Ref: 3/2023/0237

Variation of Condition 2: Plans

Variation of Condition 3: Materials

A401-A

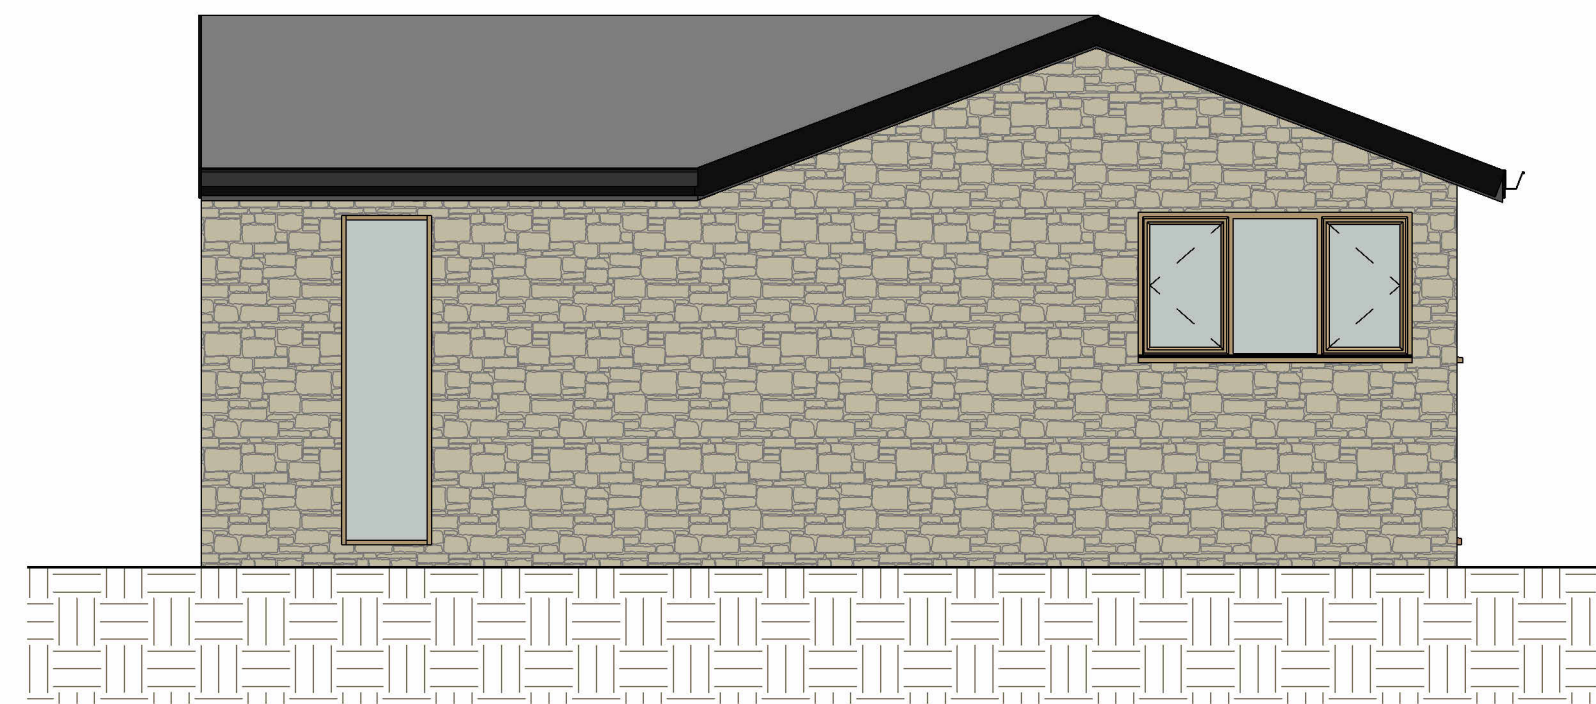
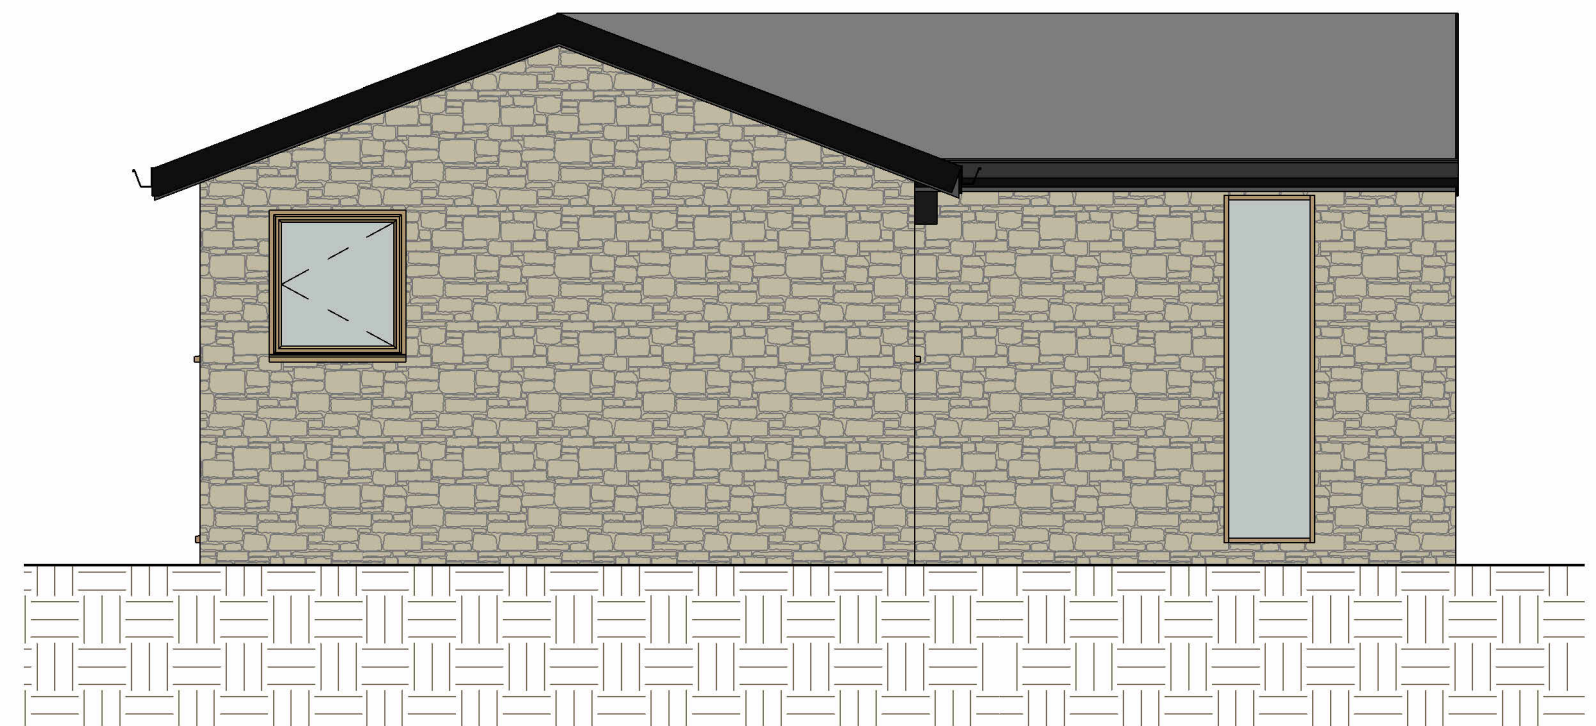
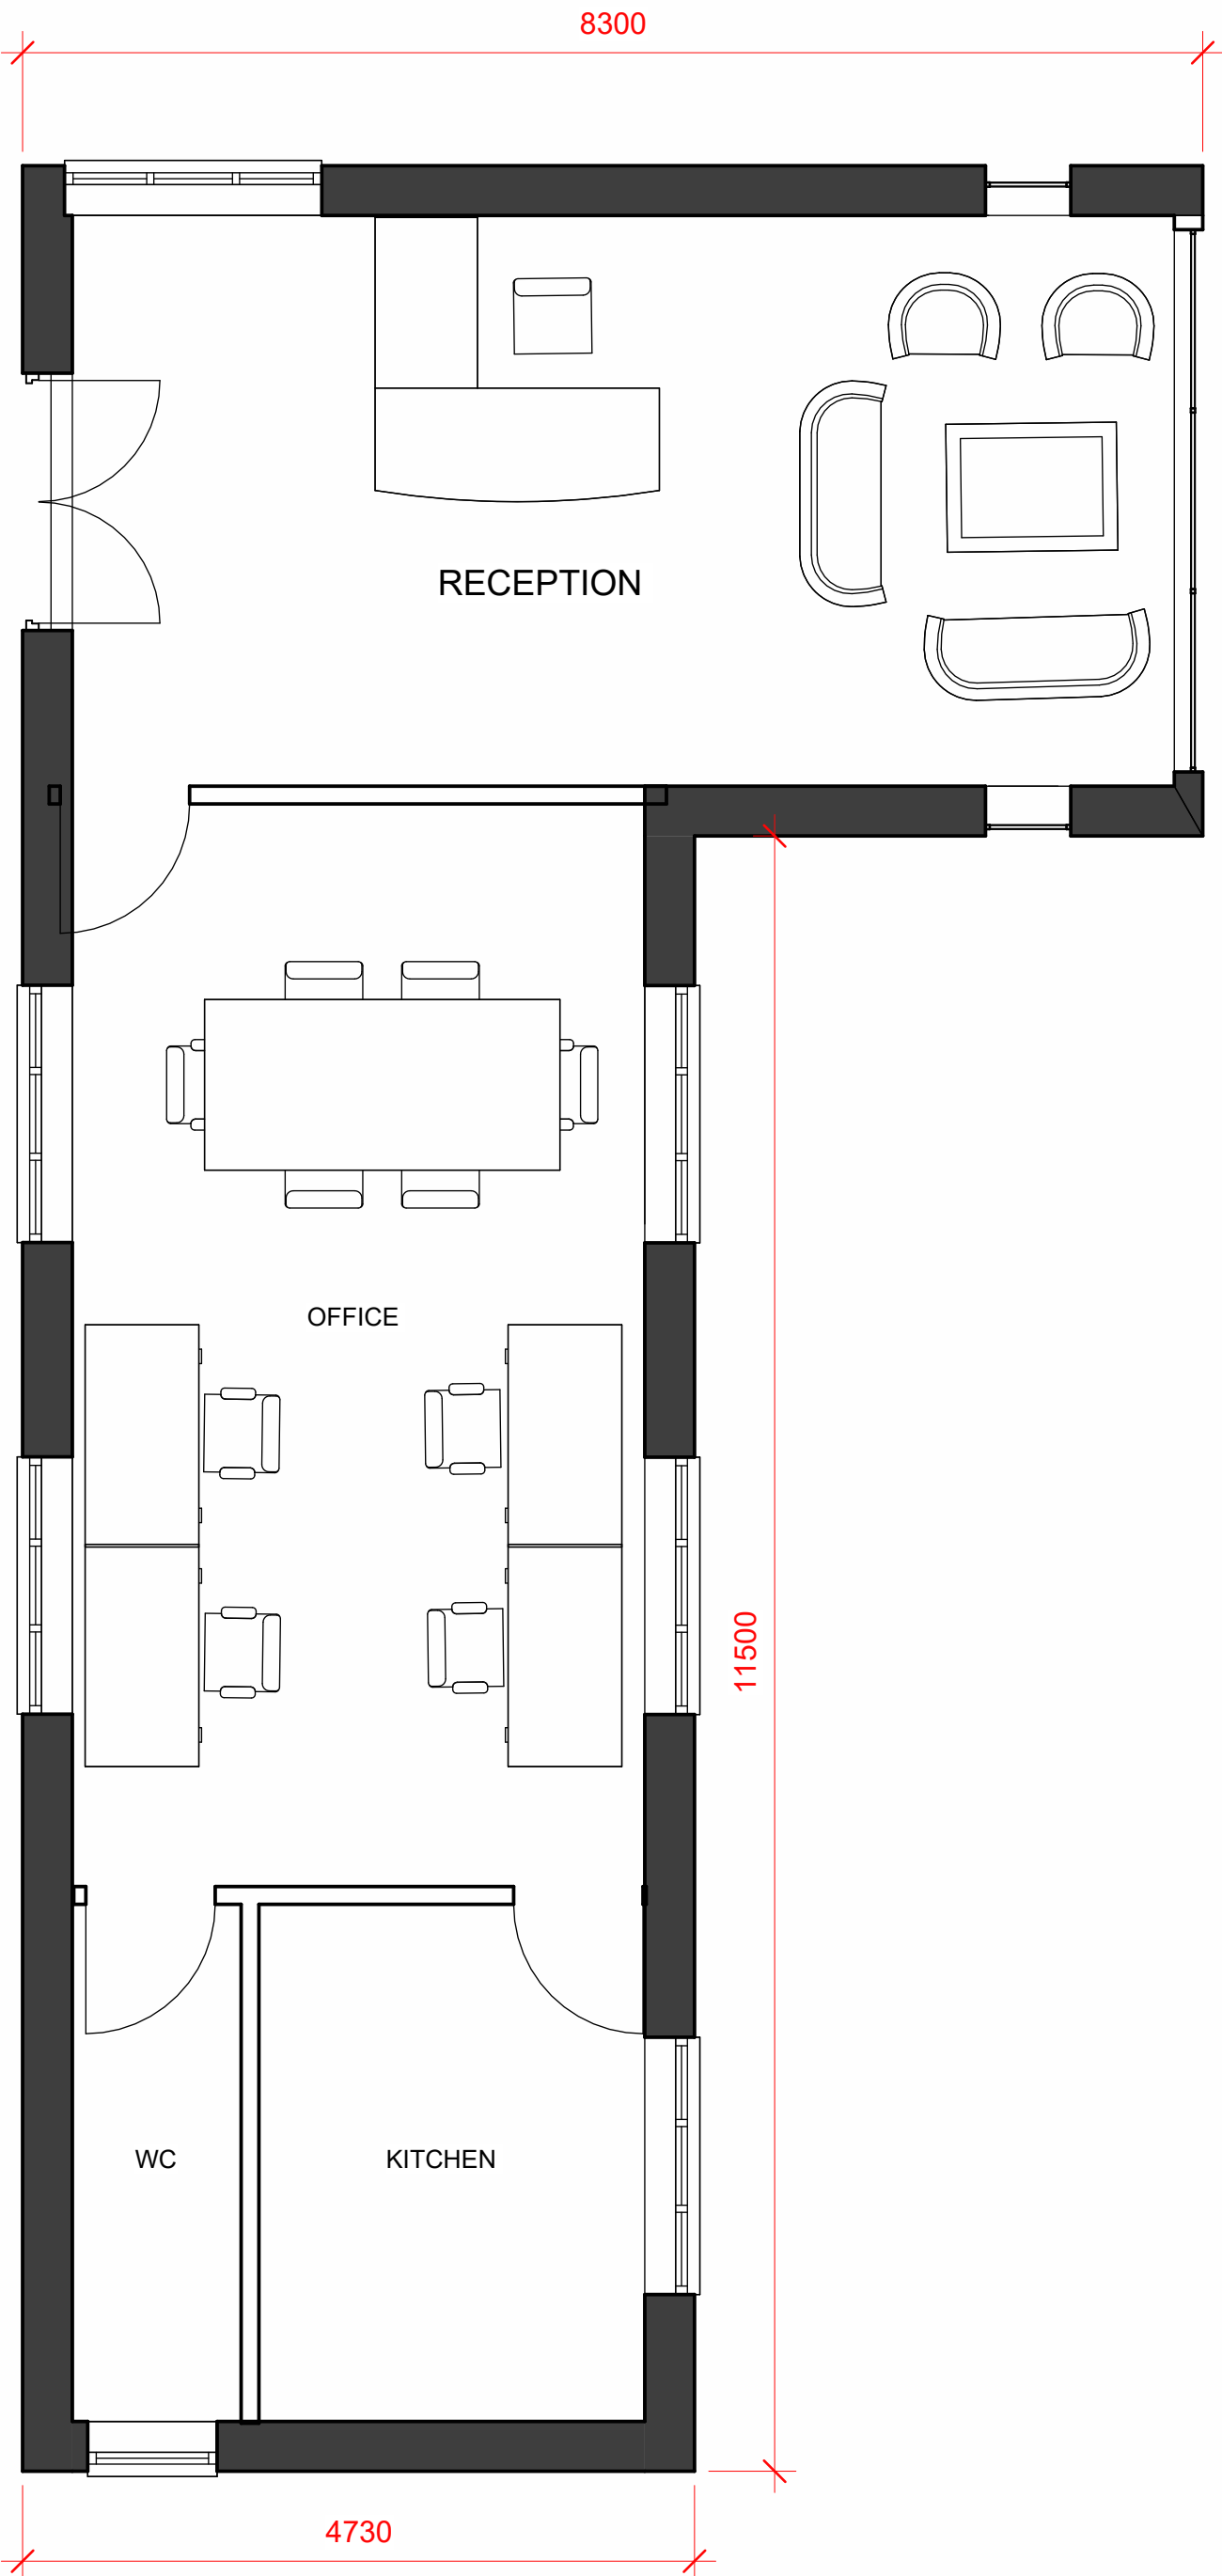
We understand from the planning application that the proposed reception building at the facility will be re-designed. However, it is unclear from the plans proposed how this will be sited on the site plan. It is unclear if there is a proposed change to the orientation of the proposed reception building.

The siting and orientation of the proposed building affects significantly how overlooked our property is and hence whether we have objections to the proposed plan alterations.

From the information available, we are supportive of the revised plans, but request that a site plan, showing the proposed alterations, is provided if the orientation of the proposed building is to be changed, as it appears. This will allow us to consider and comment fully.

We believe it is clear, as per the original planning condition, that a timber exterior more closely aligns with the policies stated above, than random stone.

In addition, we are unaware of any other non-residential buildings in the area which have outer materials of anything other than timber. The buildings that were demolished from this site (stables) were constructed from timber and we believe this material should remain, considering the proposed construction can be seen from neighbouring properties, the main road, and footpaths.

Finally, we are conscious that one of the benefits of a timber construction is the embedded carbon realised by the development. Modifying the design from timber to random stone removes this benefit and makes the develop less environmentally friendly, something that we believe should be avoided.

Considering the above, we object to the proposed alteration of materials.
